COUNTY COUNCIL'S RESPONSE TO CONSULTATION ON THE FOLLOWING DEVELOPMENT PROPOSAL

Application No: 20/01830/F

Proposal: Proposed roundabout junction

Location: Proposed Roundabout Access to Graven Hill And Wretchwick Green,
London Road, Bicester

Project **GRAVEN HILL, BICESTER**  
 Title **A41 ROUNDABOUT SURFACE WATER DRAINAGE STRATEGY**

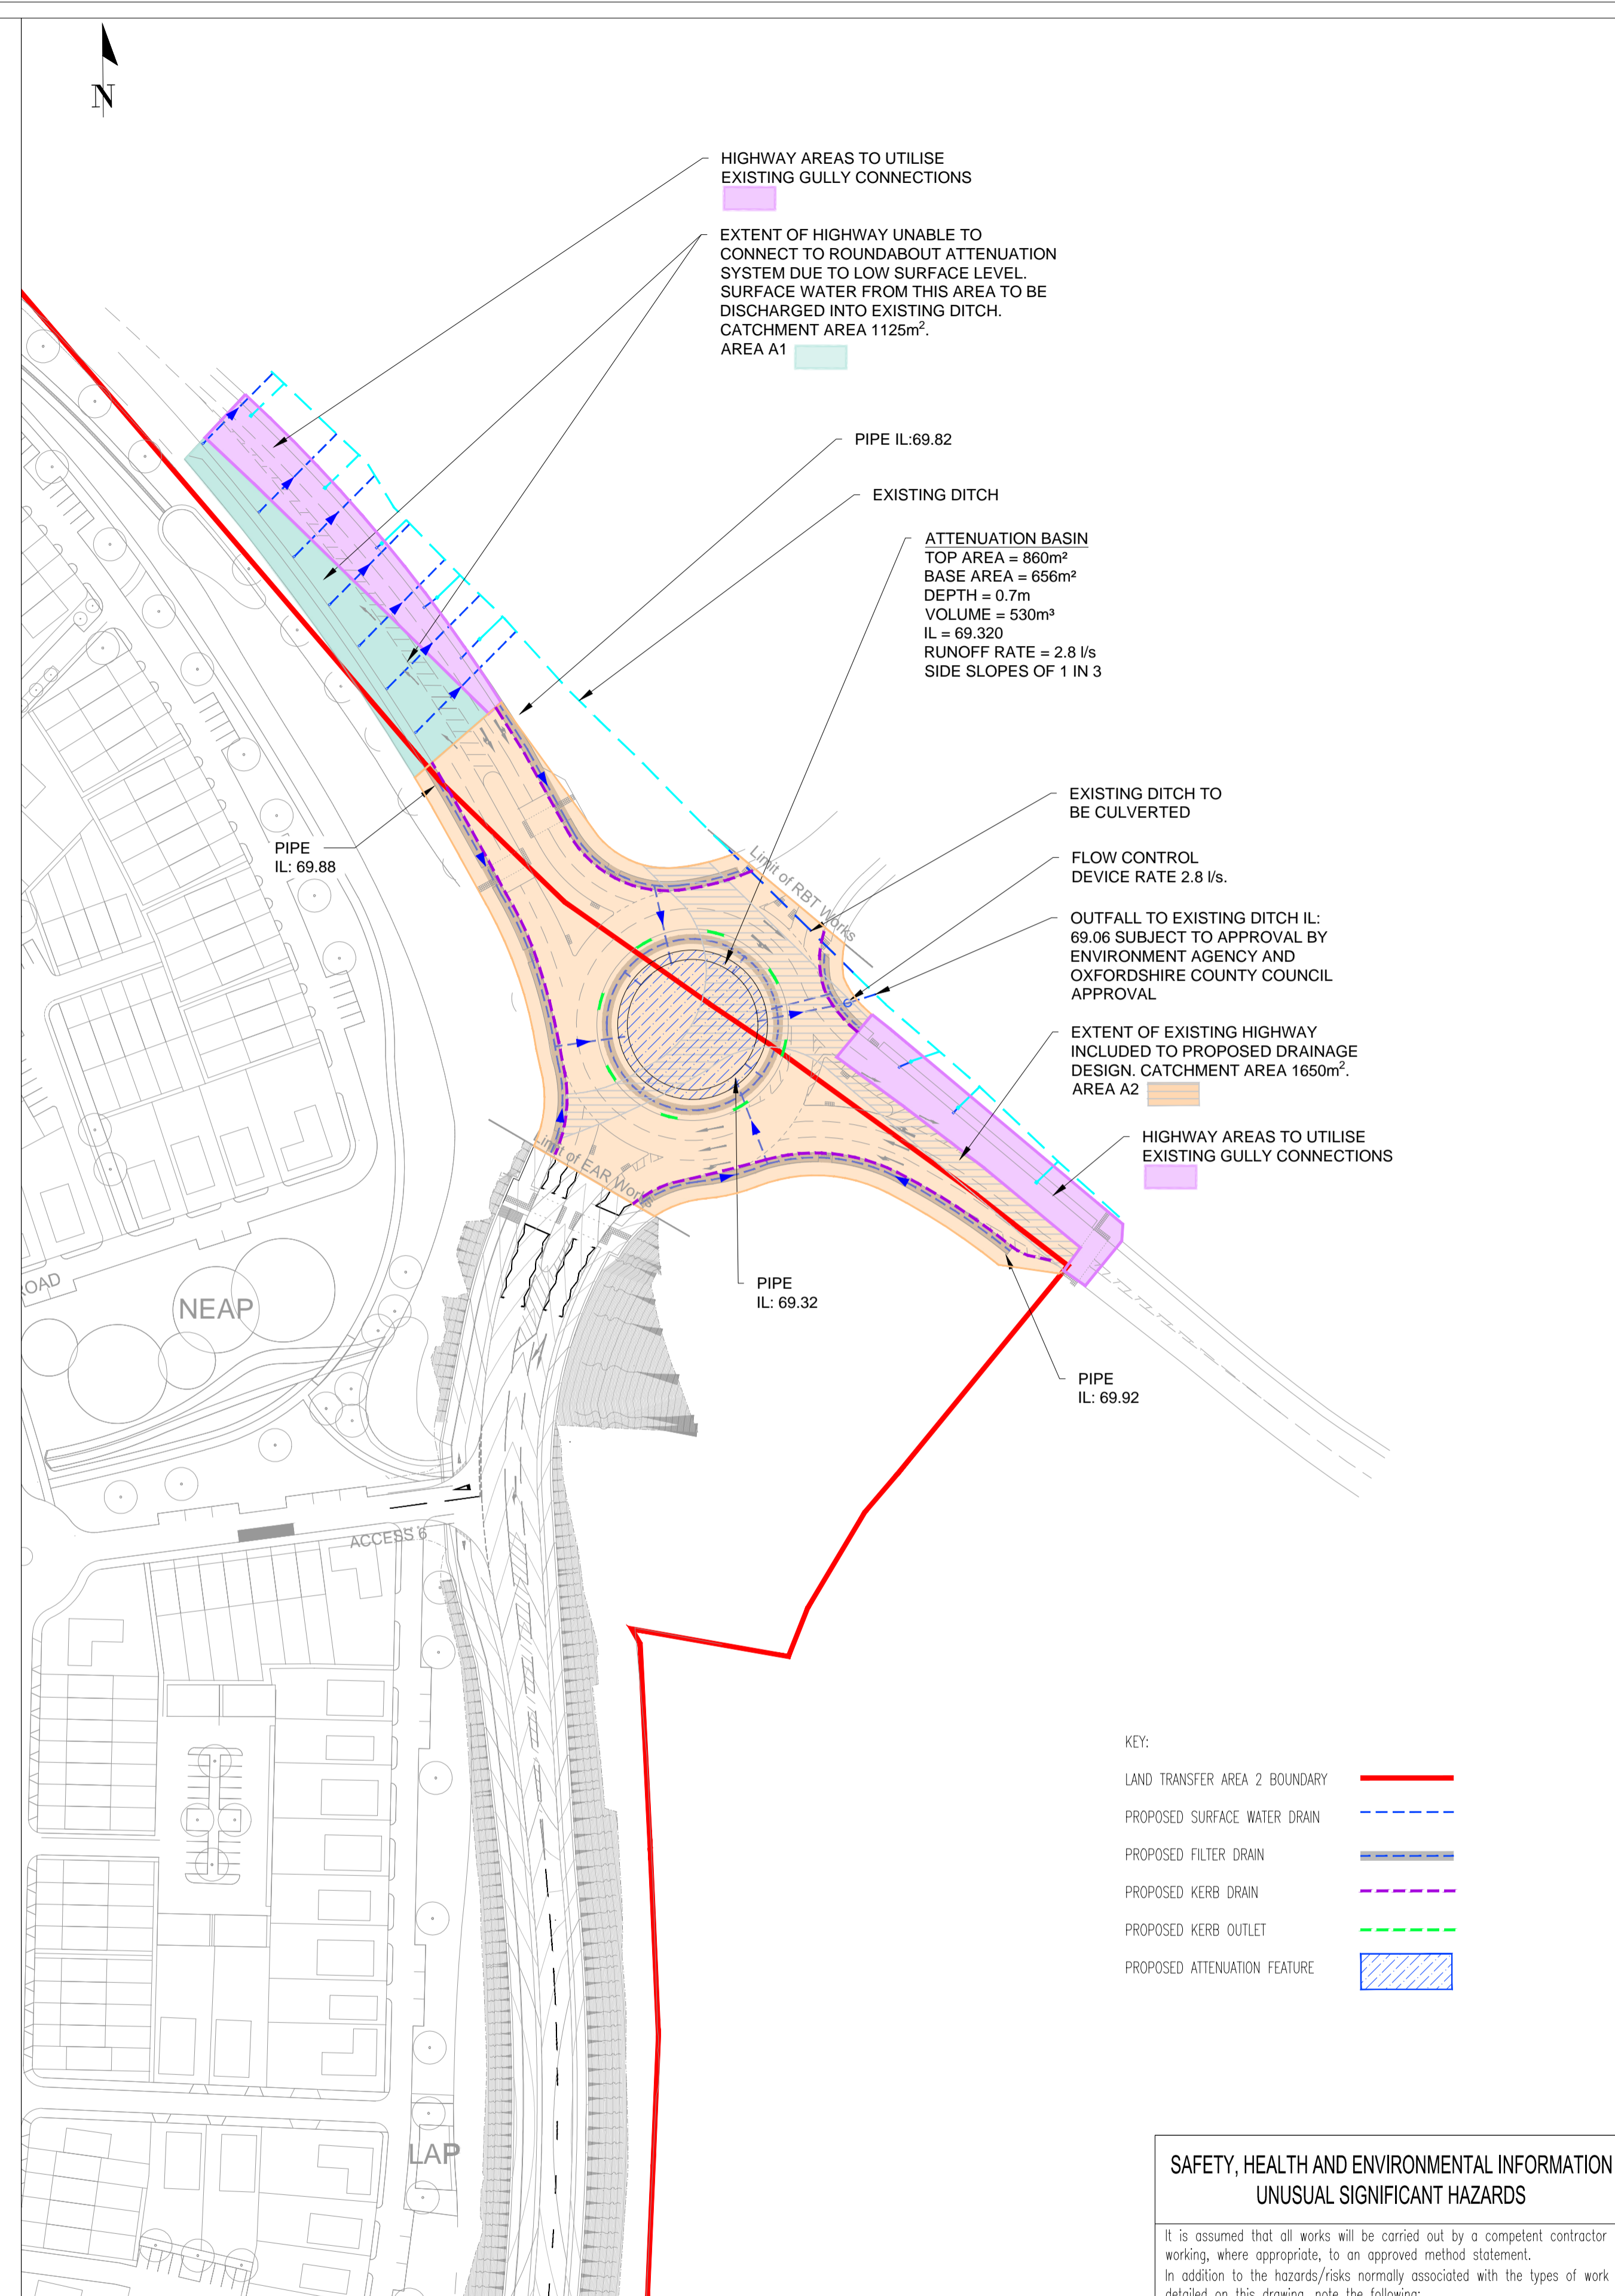
The proposed drainage strategy is predominantly reliant on Filter drains and the attenuation basin in the centre of the roundabout which is acceptable in principle.

Kerb drainage is being proposed to drain parts of the highway. This has not been detailed but combined kerb drainage must be designed out wherever possible, especially on a roundabout. Other methods such as dropped kerbs must be considered.

Further detailed information is required at the detailed design stage including cross sections of the drainage features and full calculations up to the 1 in 100 plus 40% climate change event to demonstrate that all water will be collected and managed appropriately post construction.

Construction shall not begin until a detailed surface water drainage scheme for the site, in accordance with the approved Watermans Drainage Strategy WIE11386-101-TN-1-1-2 June 2020, has been submitted to and approved in writing by the planning authority. The scheme shall subsequently be implemented in accordance with the approved details before the development is completed. The scheme shall also include:

- A compliance report to demonstrate how the scheme complies with the [“Local Standards and Guidance for Surface Water Drainage on Major Development in Oxfordshire”](#);
- Full microdrainage calculations for all events up to and including the 1 in 100 year plus 40% climate change;
- A Flood Exceedance Conveyance Plan;
- Detailed design drainage layout drawings of the SuDS proposals including cross section details;
- Detailed maintenance management plan in accordance with Section 32 of CIRIA C753 including maintenance schedules for each drainage element; and
- Details of how water quality will be managed during construction.
